Please ask for: Nicola Moore
Email: nicola.moore@arun.gov.uk
Telephone: Ext 37944
Our Ref: BR/122/20/OUT
Your Ref:
Date: 31st July 2020

Application for Outline Planning Permission

Development: demolition of garth house and west view to be replaced with 20 self contained apartments
Location: Garth House High Street Bognor Regis PO21 1HQ

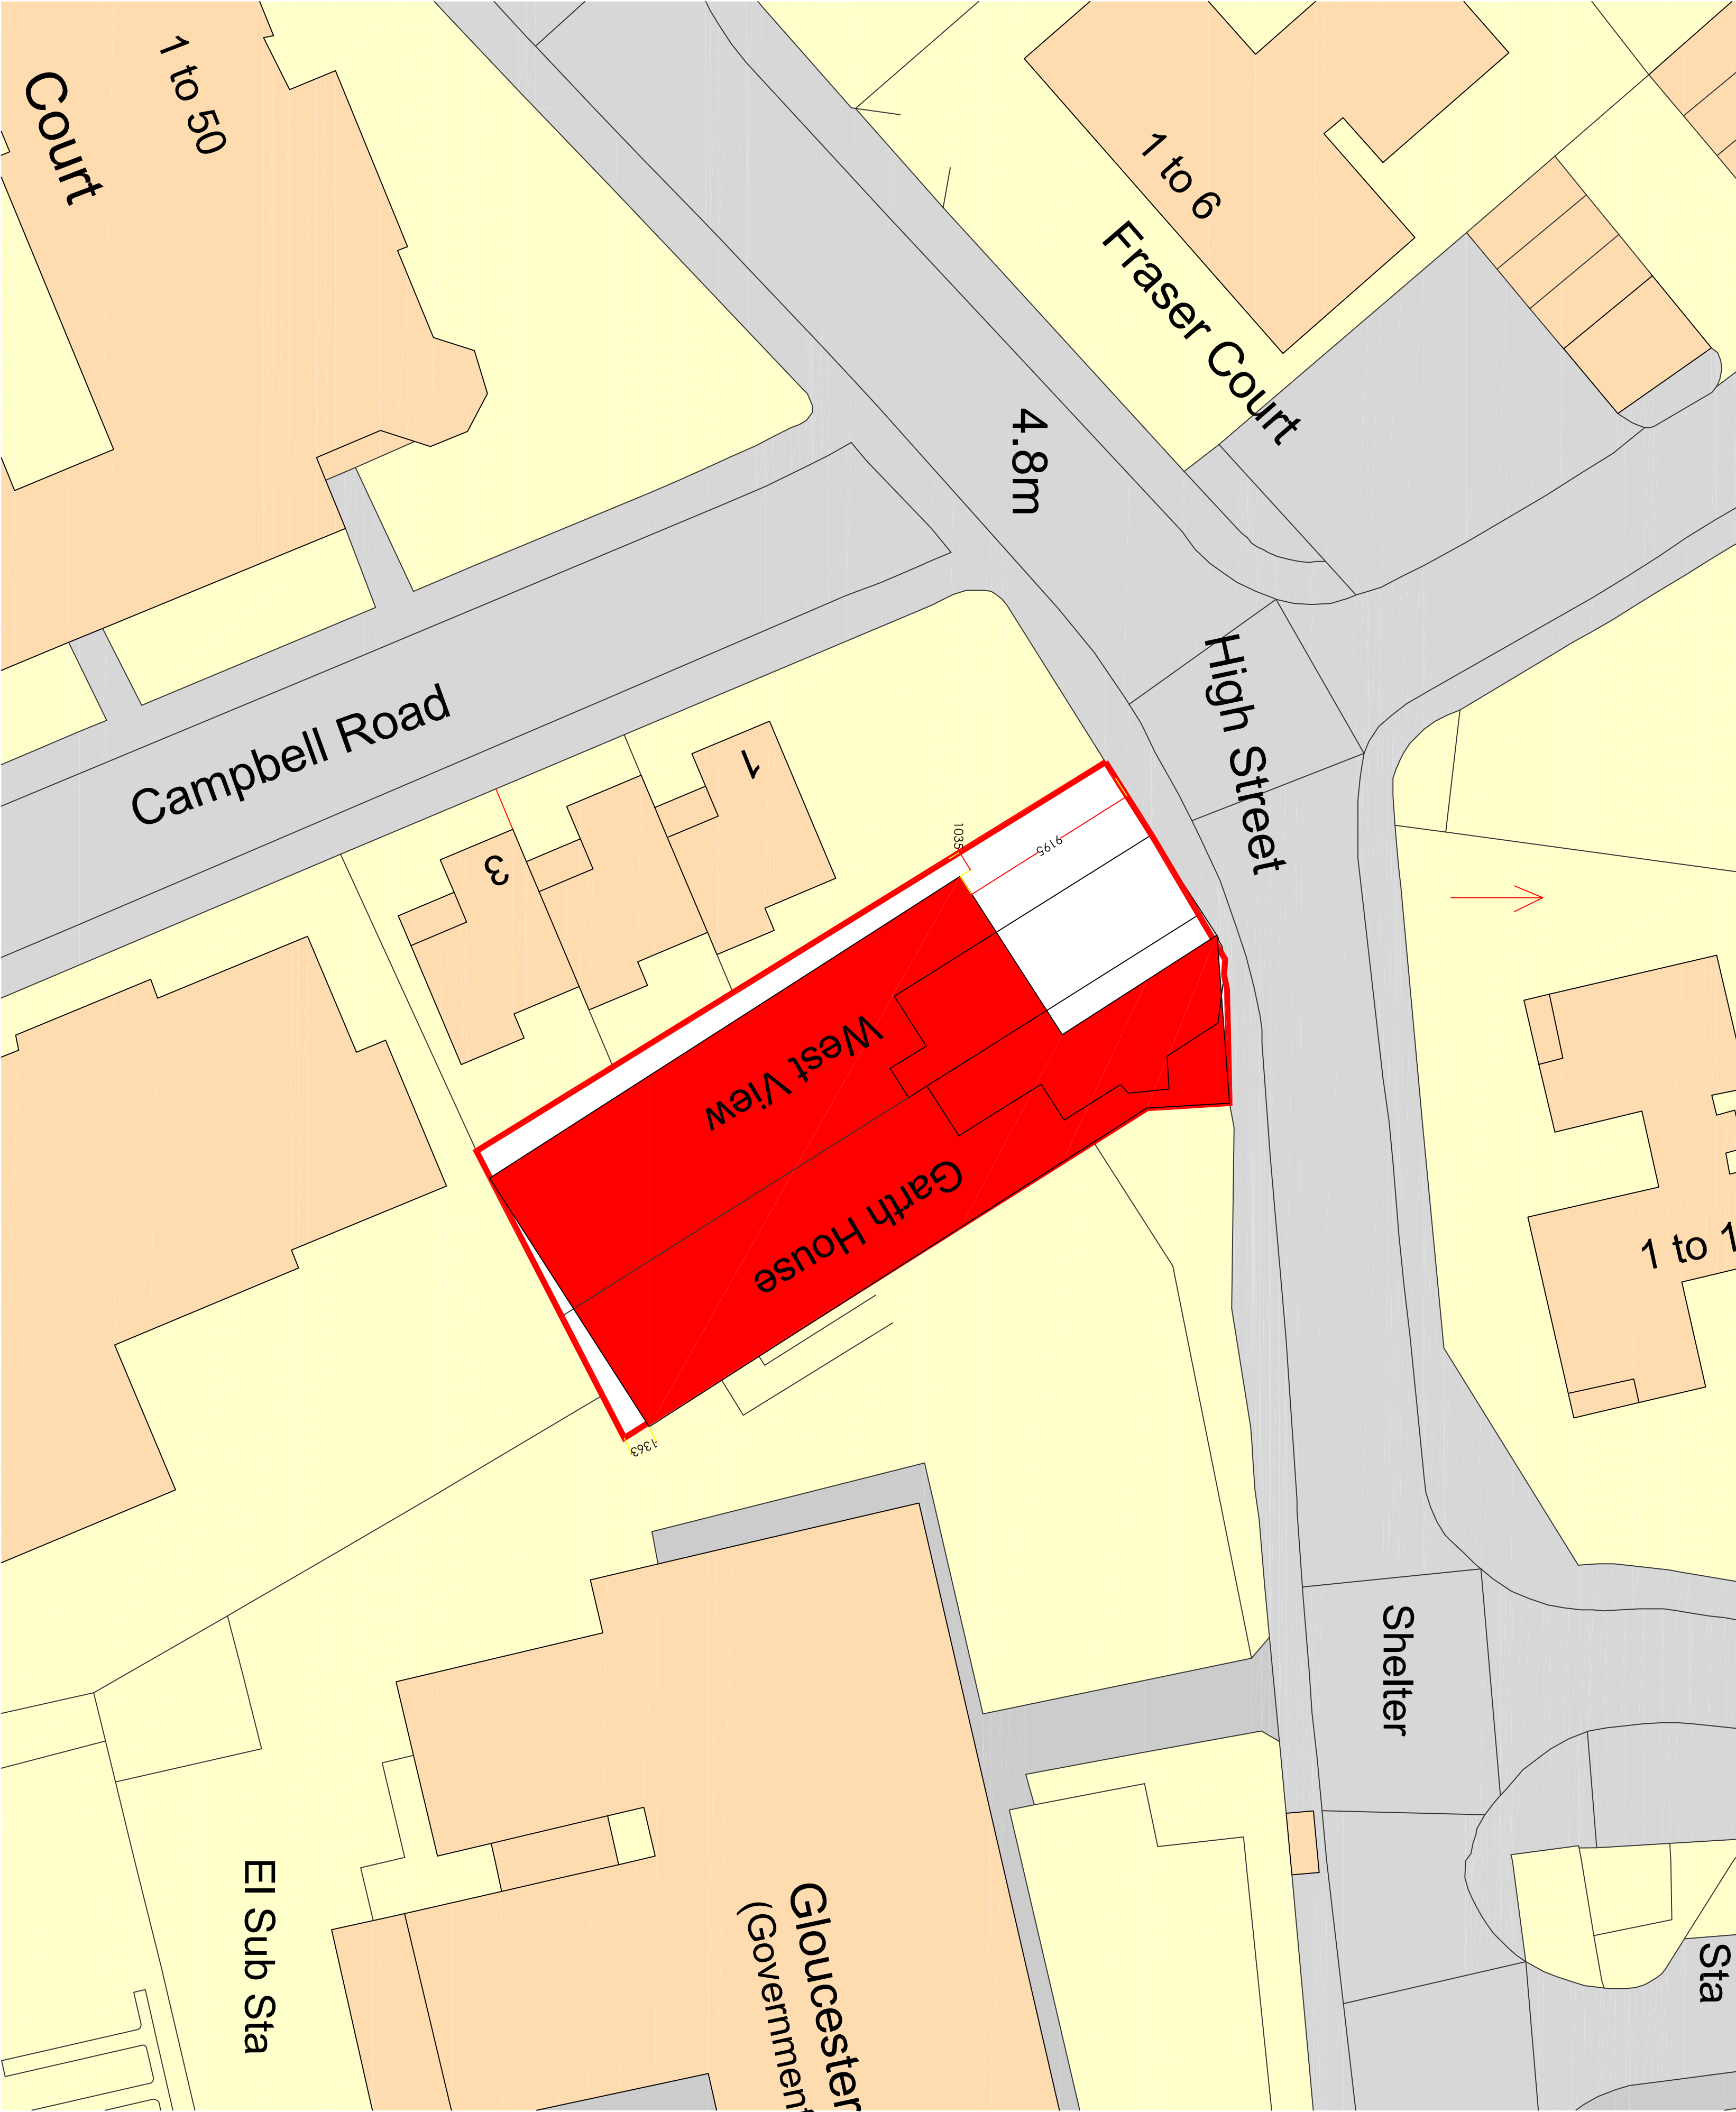
Please amend the Block Plan to show the direction of North and remove red edges that are not applicable to the application site. The Block plan should also include the footprint of the demolished building/s and all measurements to boundaries of the proposed development. Please submit at a scale of 1:500 or 1:200

West Sussex County Council require that a visibility splay is provided. A splay is formed for a 30 mph speed limit road by measuring from a point 2.4m back from the kerb edge in the centre of the proposed access. A line should then be drawn from either side of this point for 43 m in each direction to the nearside edge of the carriage way. The splays must intersect land only within the control of the applicant, or within the publicly maintained highway.
